Recommendation Report for Planning Permission

REF NO: Y/117/19/PL

LOCATION: The Crickets
Hoe Lane
Flansham
PO22 8NT

PROPOSAL: Extension & alterations to main dwelling and extension and conversion of existing annexe to three holiday letting units (resubmission following Y/74/19/PL).

Proposed Extension and Conversion
at The Crickets, Hoe Lane, Flansham
for Mr B Brogan
Drawing P10 December 2019 Scale 1:100 @ A3
Planning Drawing - Ground Floor Plan

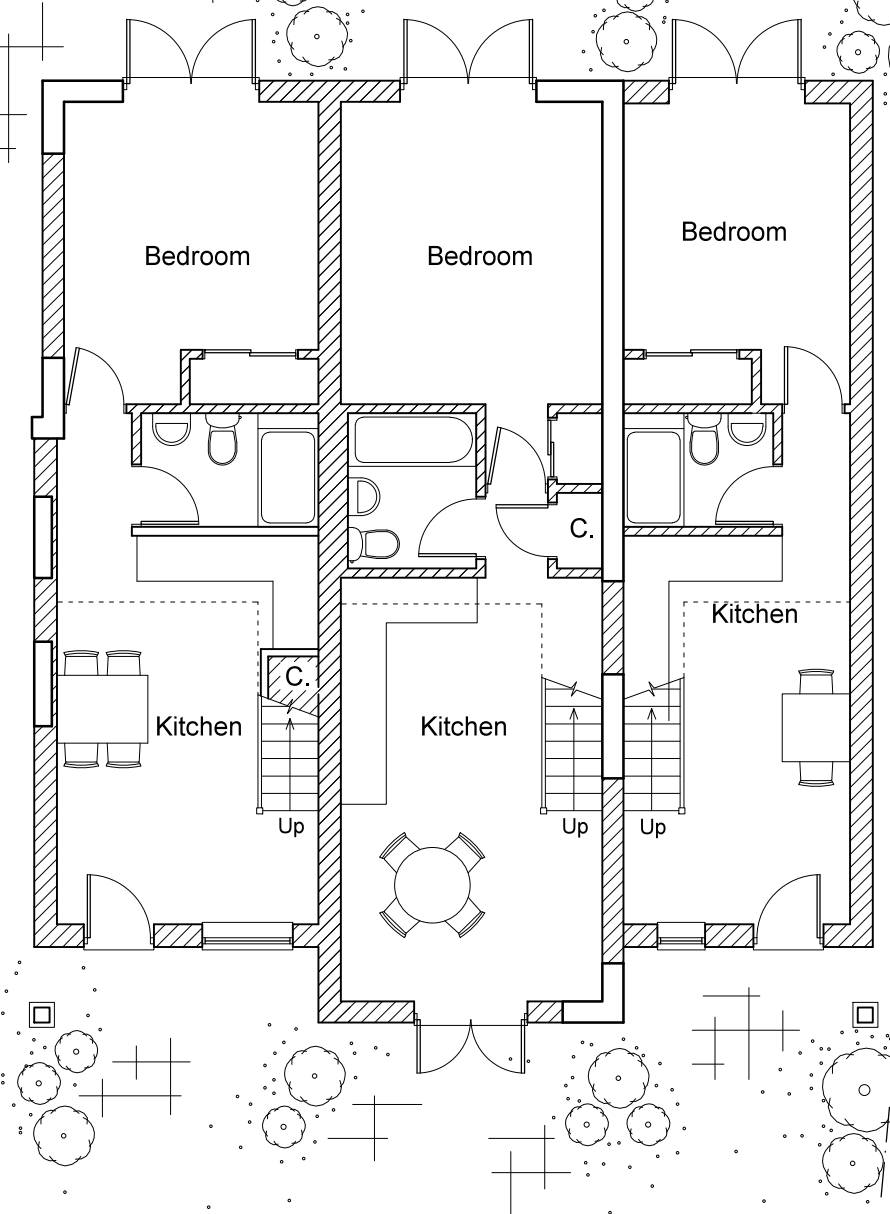
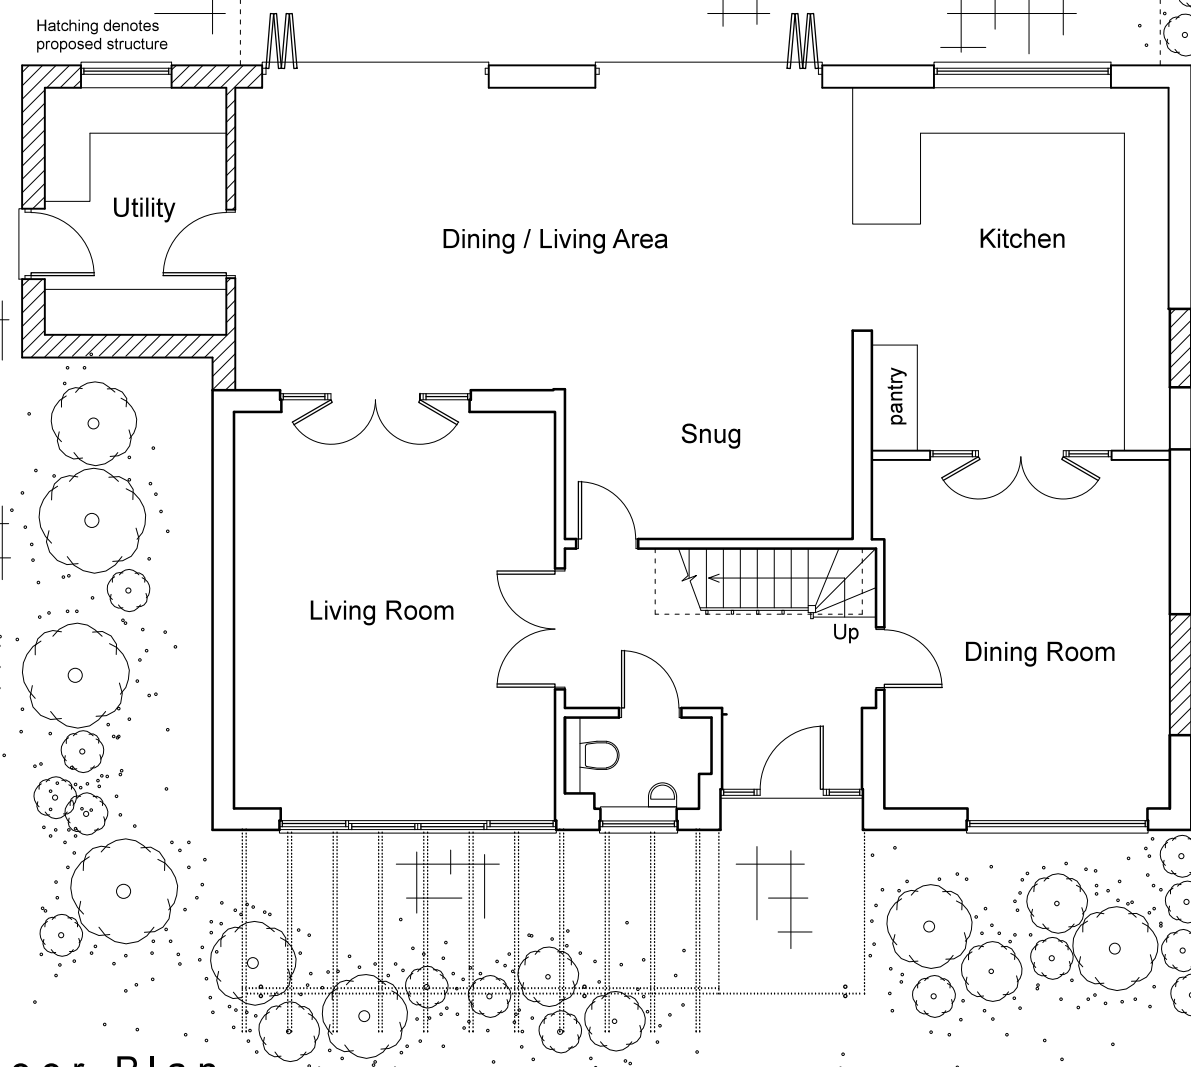
- The proposed parking layout plan does not sufficiently demonstrate that the 7 indicated parking spaces are adequate for the whole site or that they have adequate turning and manoeuvrability space to enable cars to easily access the proposed spaces unhindered and all times. No disabled parking bay has been provided for the proposed commercial use ie holiday lets. YPC request that the viability of the proposed parking is clearly demonstrated by full tracking being submitted.

The proposed conversion and extension of an existing annex to three holiday units would result in an overdevelopment of the site with proposed parking for 7 cars dominating the front whilst parking provision especially in countryside should be subordinate to the building and landscape setting. Therefore it is considered the proposal would cause harm to the character of the pattern of development in countryside. In addition, it is likely that occupiers of the proposed holiday units would be heavily reliant on motor vehicles for travelling to and from the site. With few services or facilities available locally, any benefit which the conversion might bring to the local economy is likely to be limited.

Proposed Extension and Conversion
at The Crickets, Hoe Lane, Flansham
for Mr B Brogan
Drawing P12 December 2019 Scale 1:100 @ A3
Planning Drawing - Roof Plan & NW Elevation

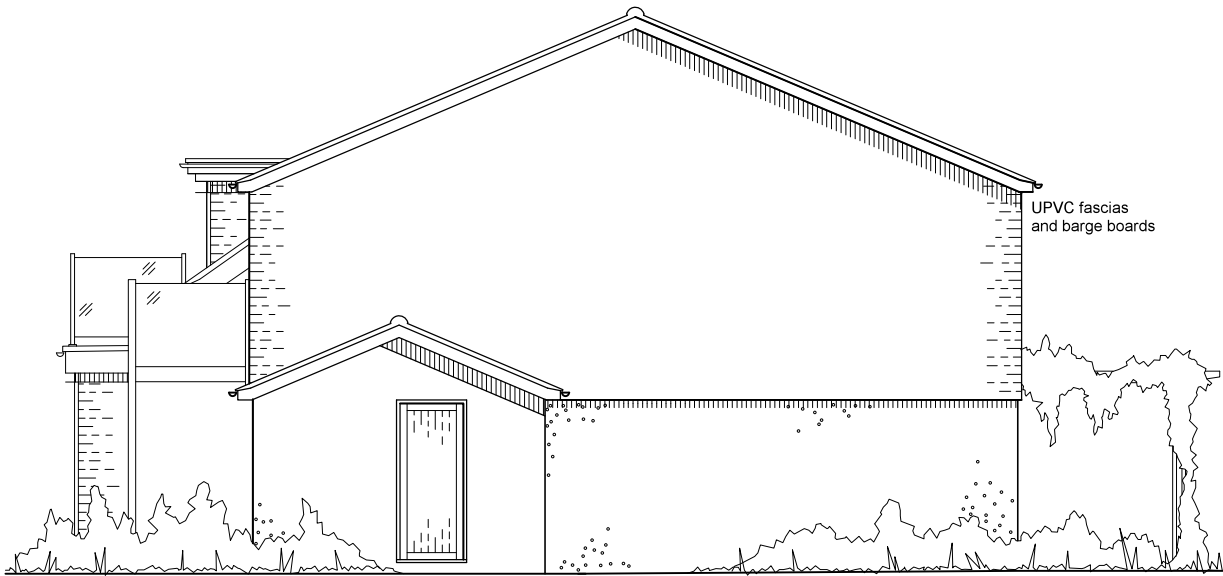
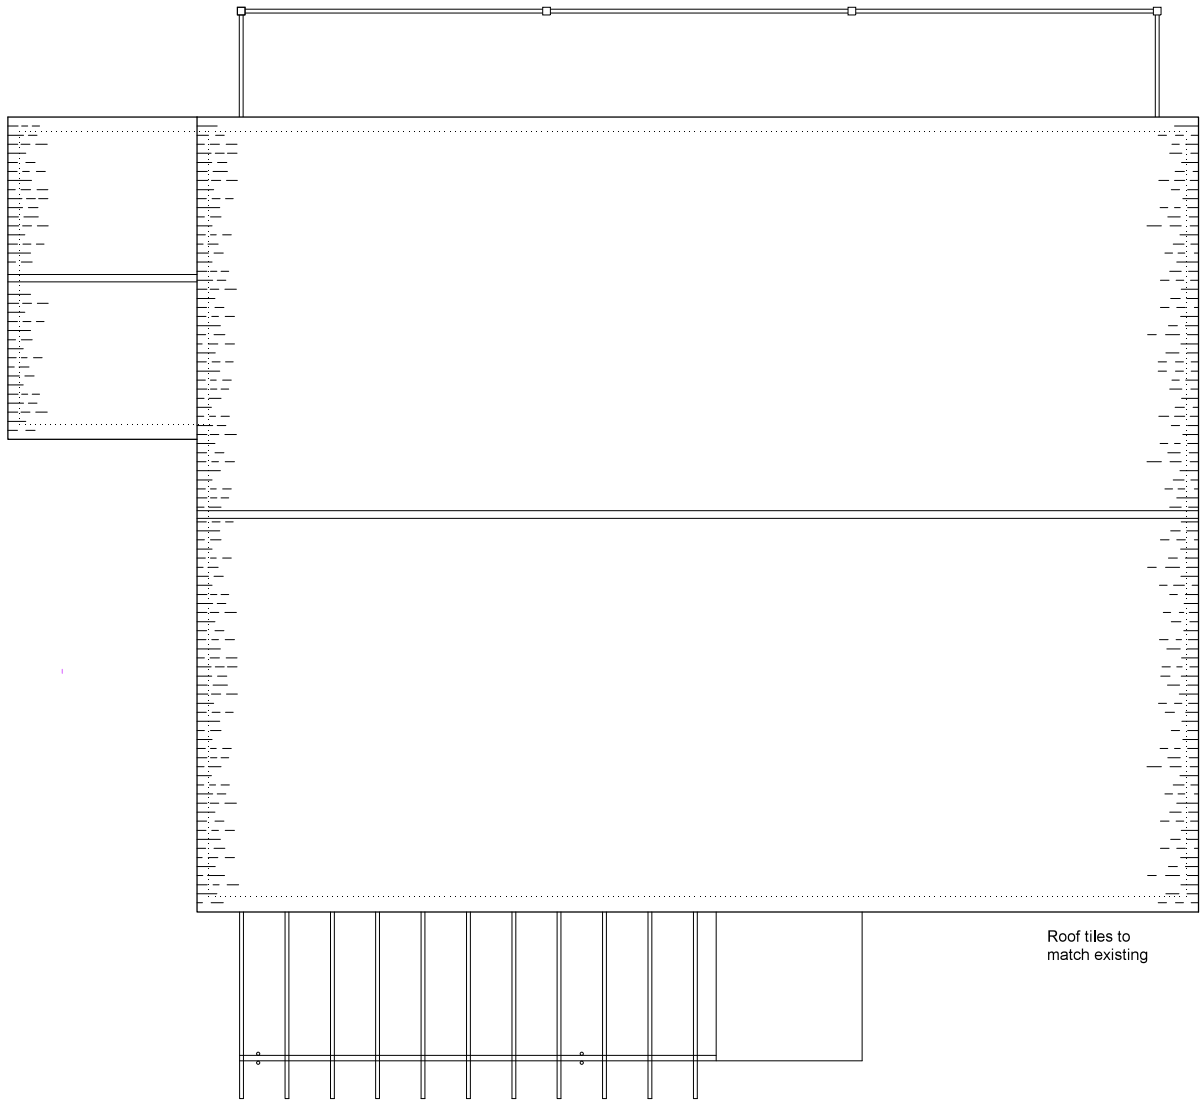
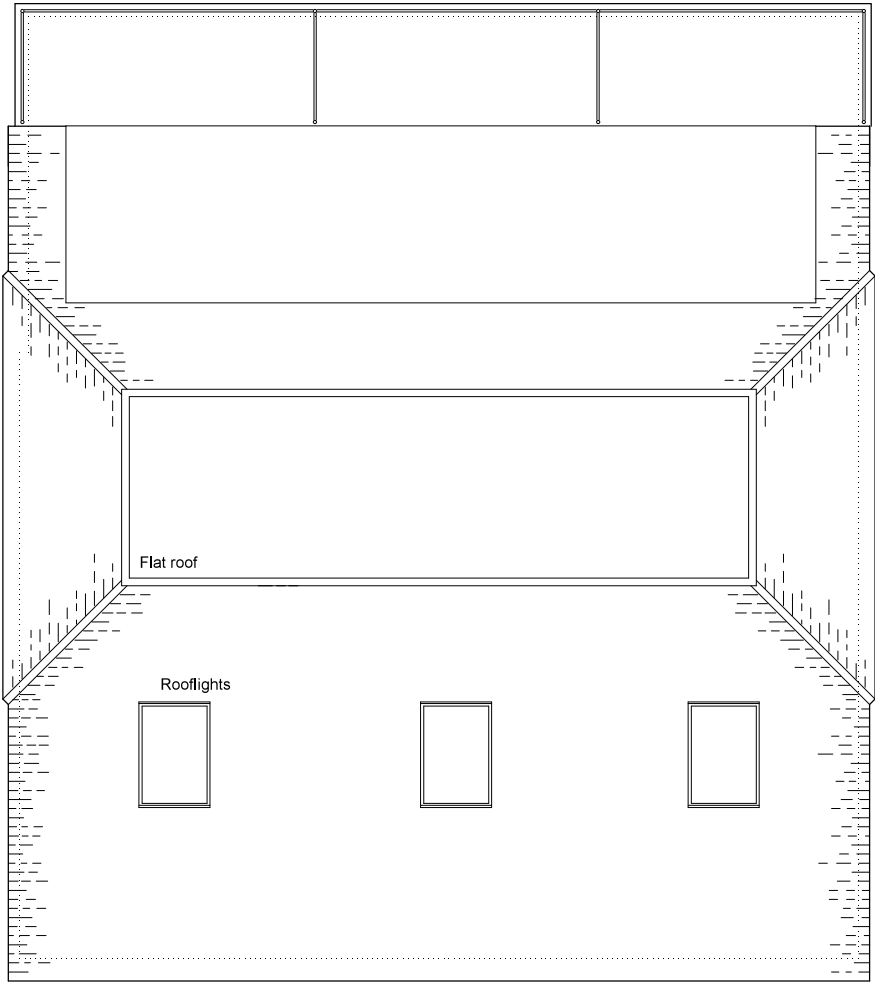
The proposed extension of the host building would be acceptable, however submitted drawings show the raise of the existing roof ridge by 0.7m without justification.
